March 3, 2023

Re: Ellicott Sand and Gravel Special Use and Mineral Extraction Permits

SUBJECT: Review of Ellicott Sand and Gravel LLC Mine Permit Application

Map of water well logs to illustrate depth of resource.

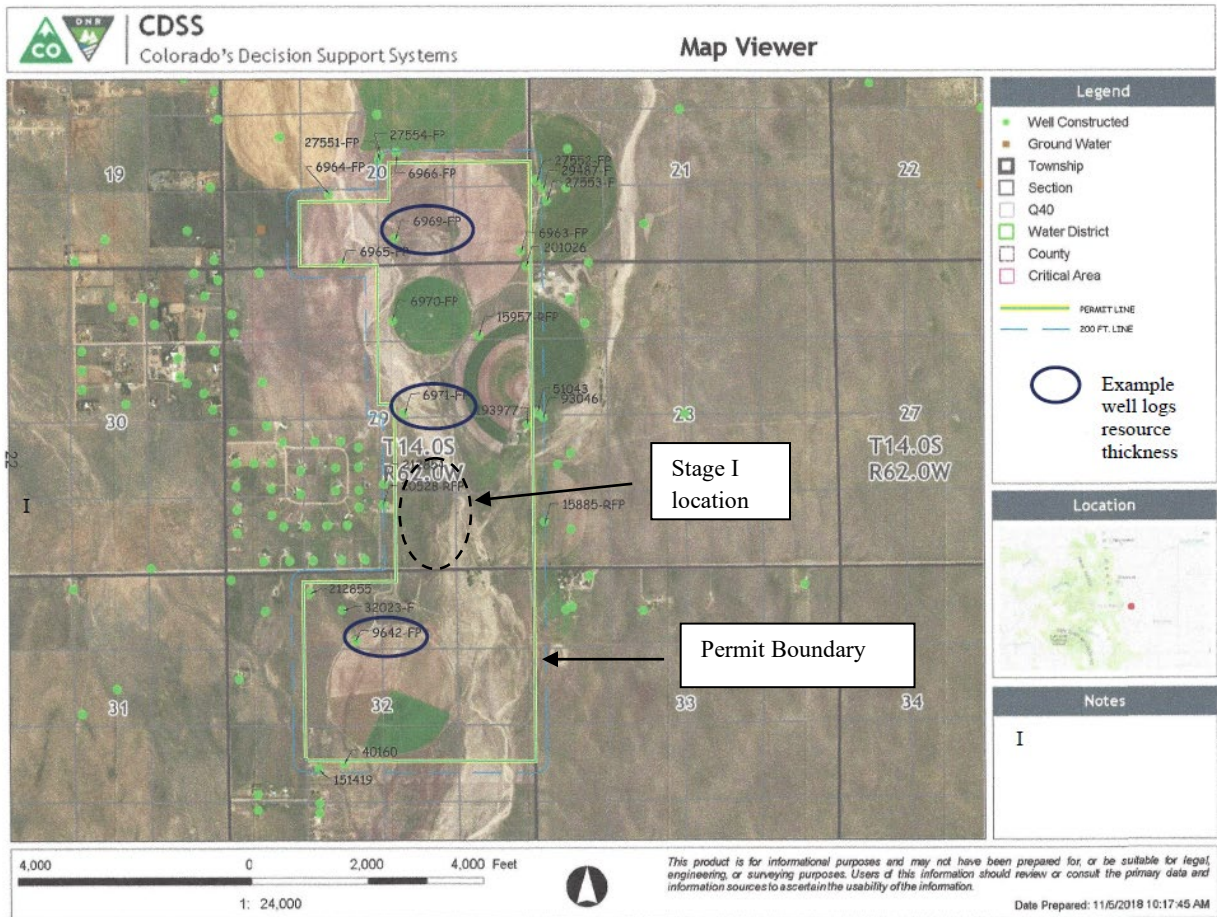
Applicant also concludes that the depth to groundwater is more than seventy feet and bases this conclusion on a review of twenty-four wells. The depth to water data for these wells has not been provided. Additionally, only six of the twenty-four wells are screened in the UBS alluvial aquifer while the remaining eighteen wells are bedrock wells and are not appropriate for determining depth to water in the overlying alluvial aquifer. Without this data it is unclear how Applicant will ensure that mining will not occur within ten feet from the groundwater table in the UBS alluvial aquifer as Applicant proposes.

STAGE 1 OF 6 - GRADING AND EROSION CONTROL PLANS

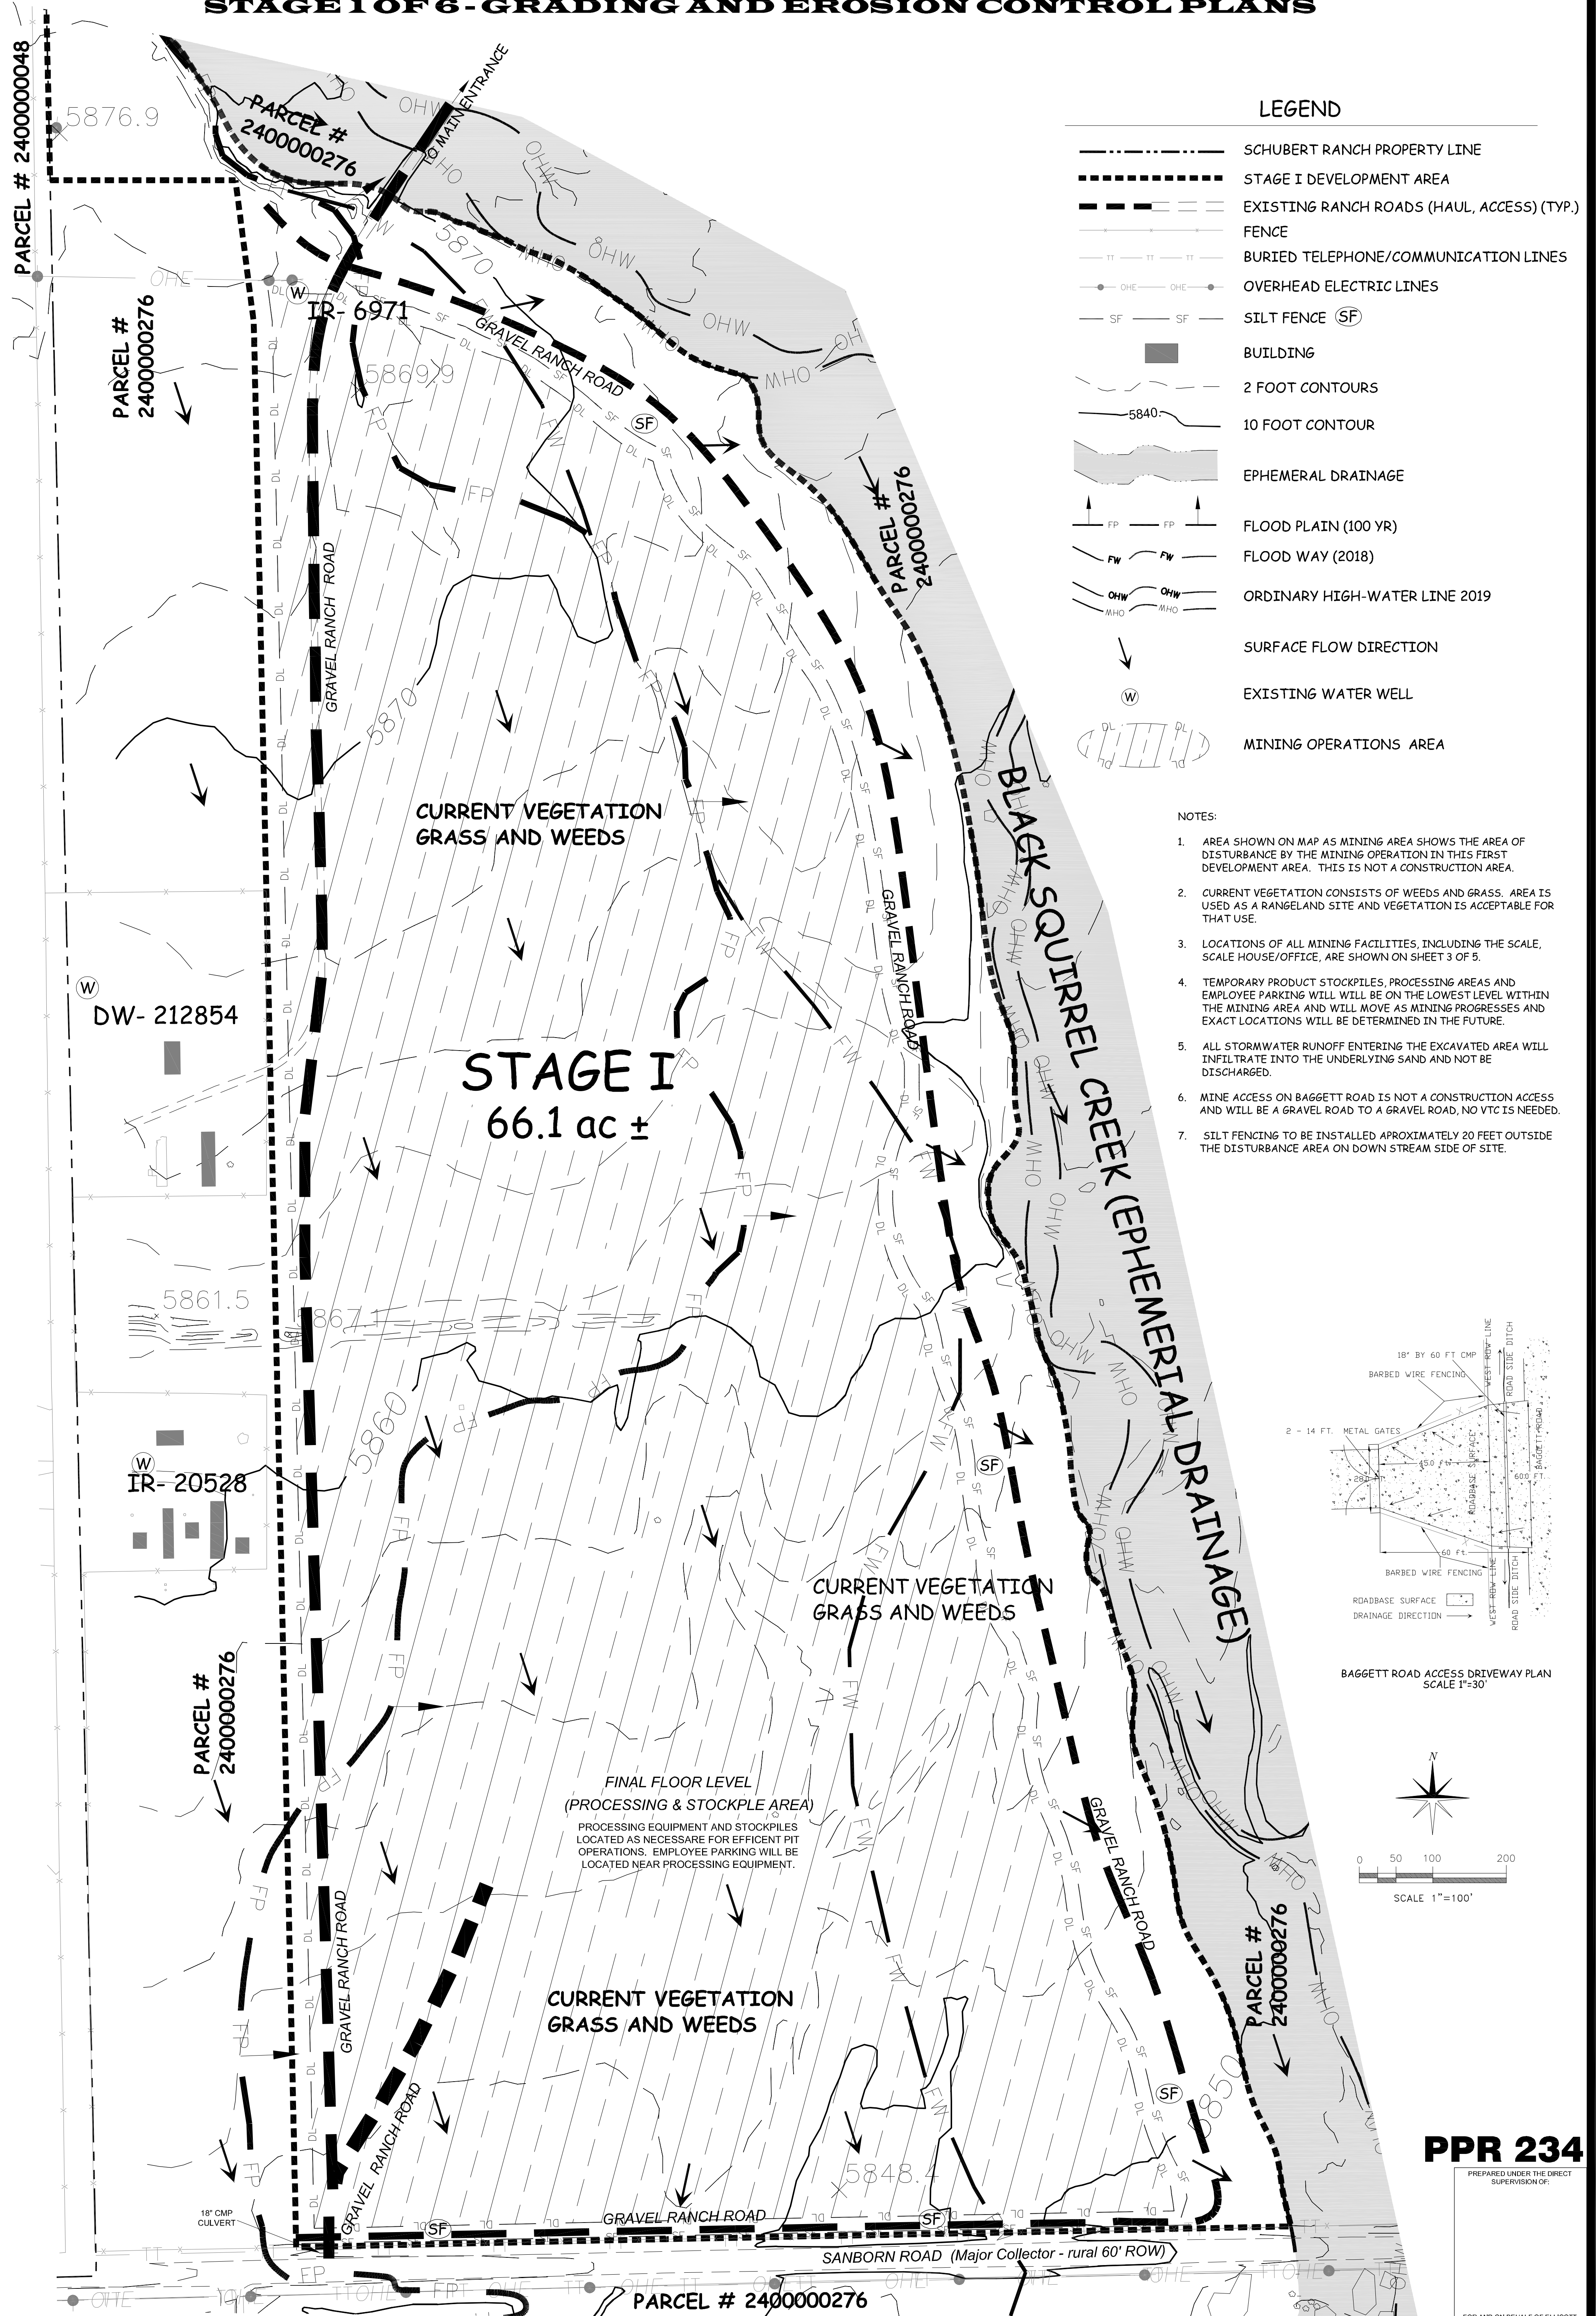
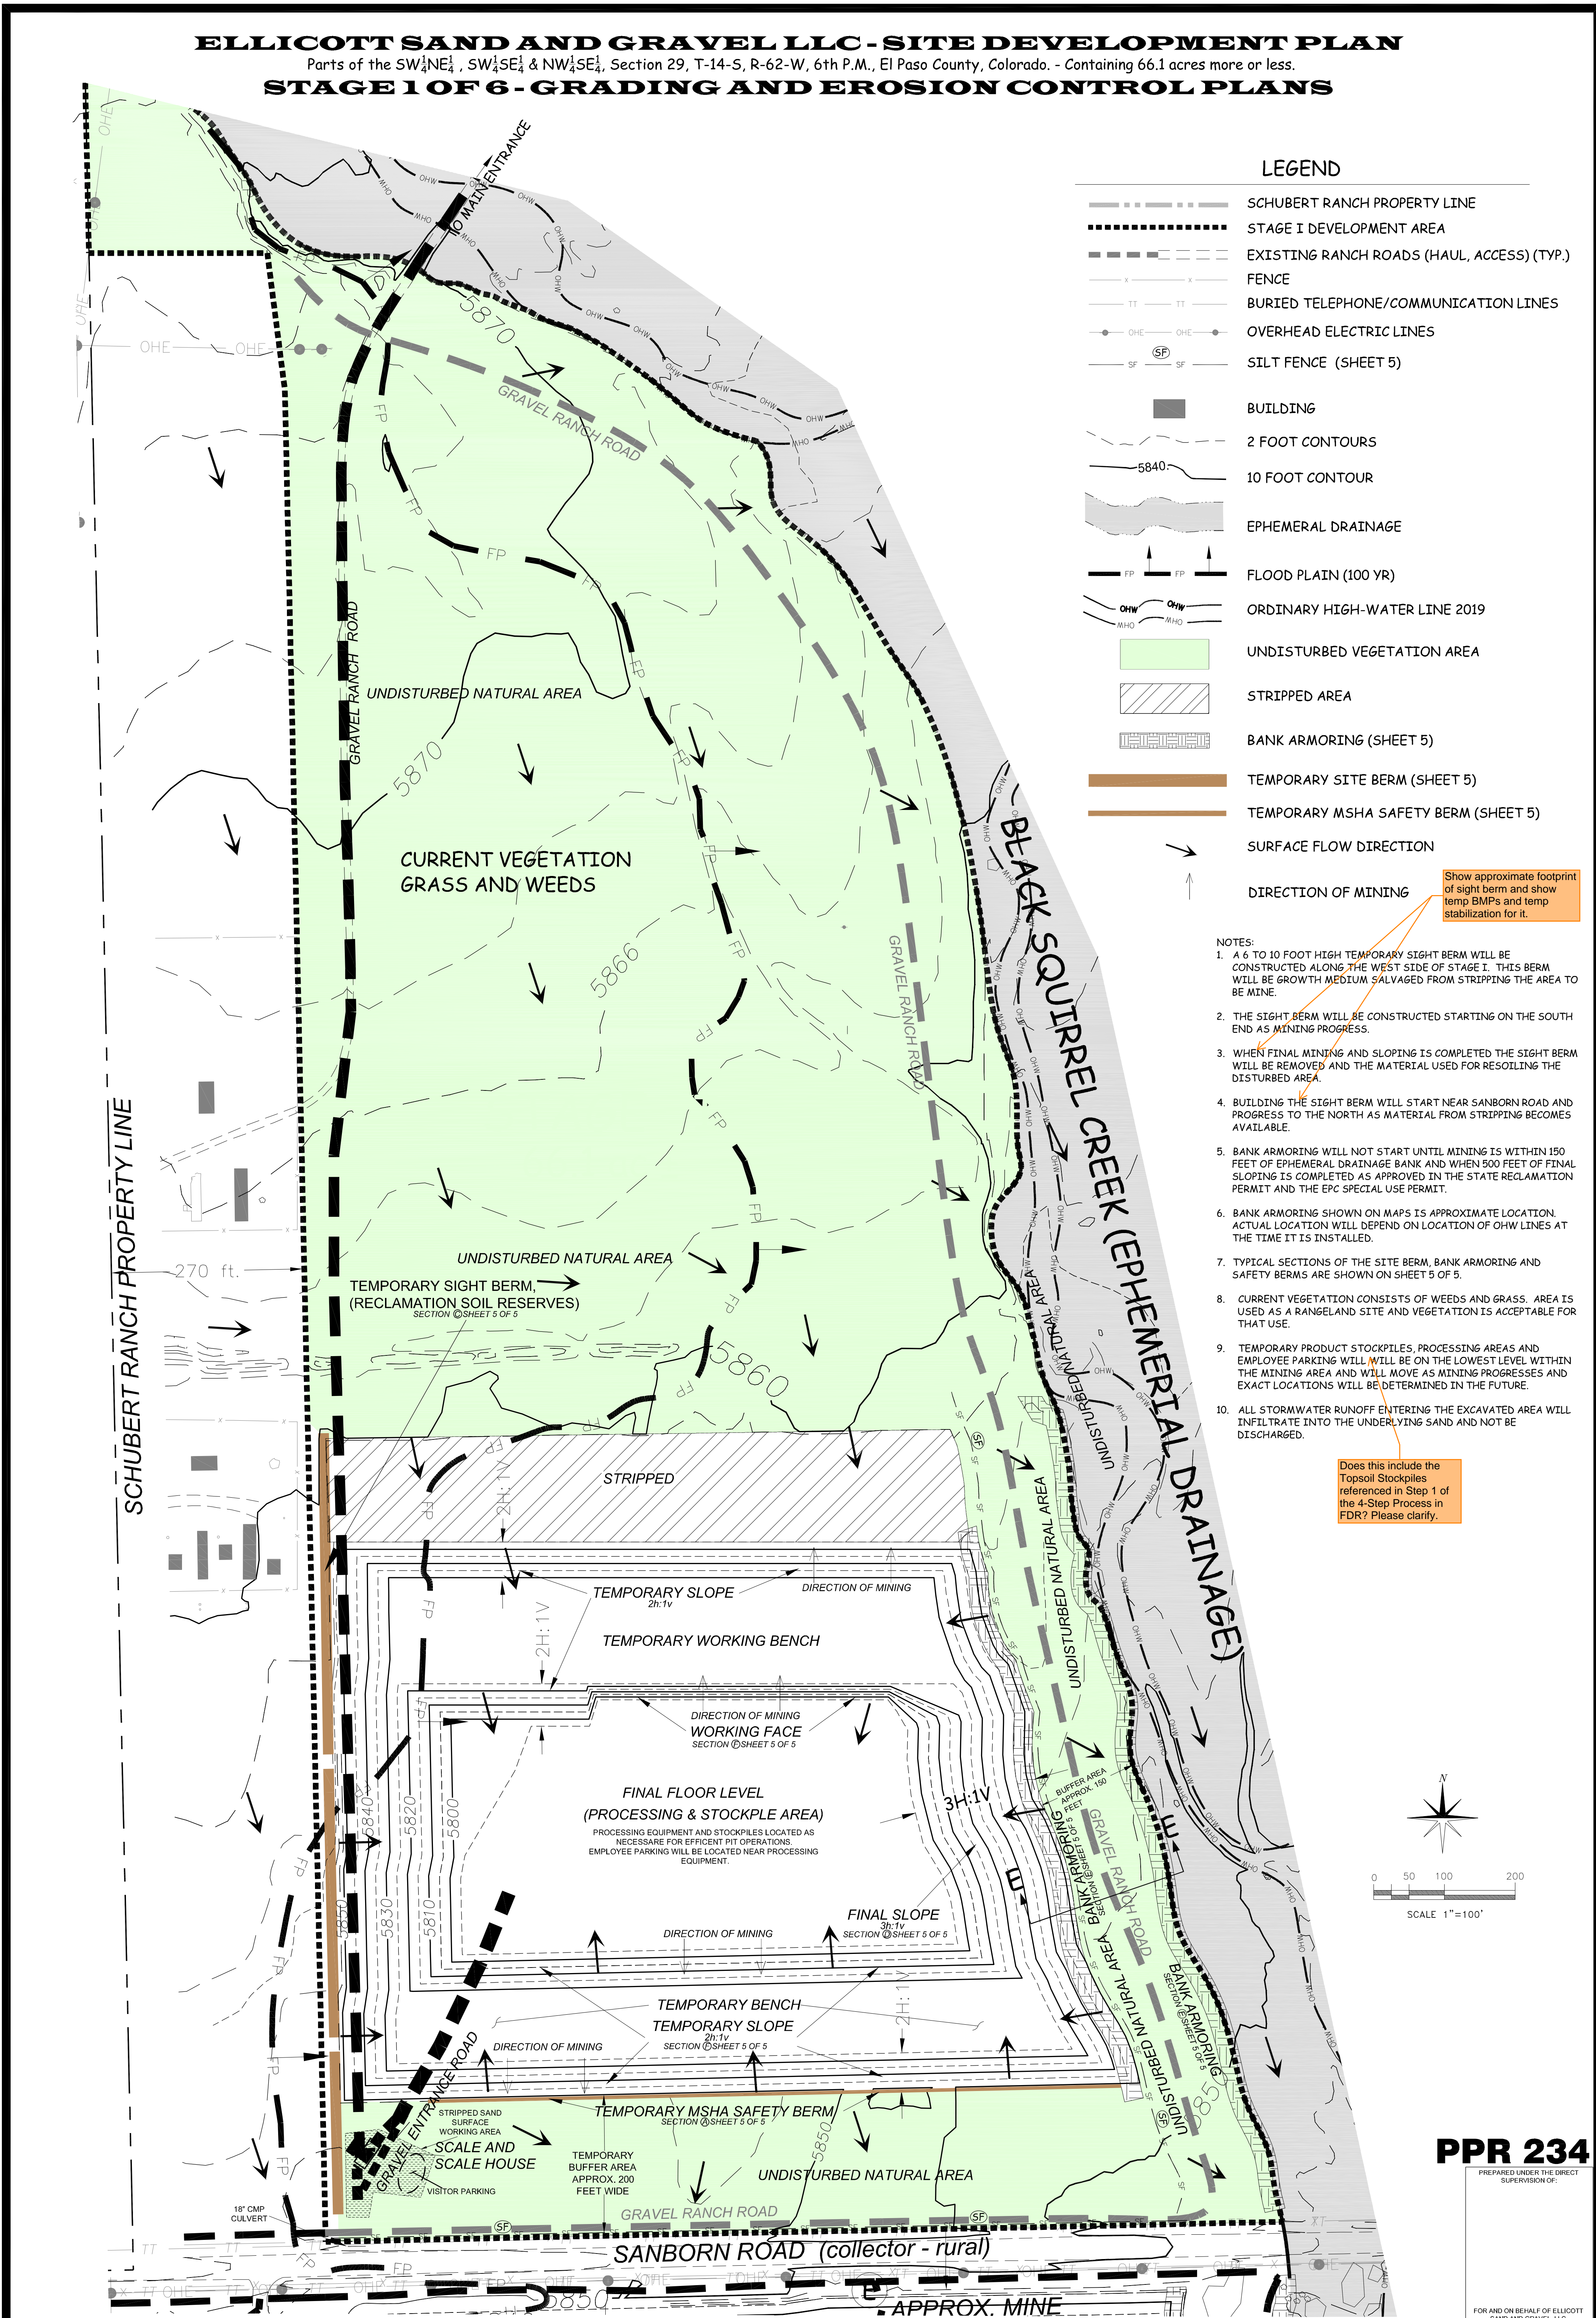
The operation will create numerous pits that extend up to seventy feet below the surrounding landscape that will receive and store water. Applicant does not provide information on whether or how the creation of these pits will alter the current surface drainage around and through the site. Applicant indicates that captured stormwater in the pits will be released within

seventy-two hours and, if not, Applicant will file for a replacement plan to replace evaporative losses. To date, Applicant has provided no indication of Applicant's intended compliance with these requirements.
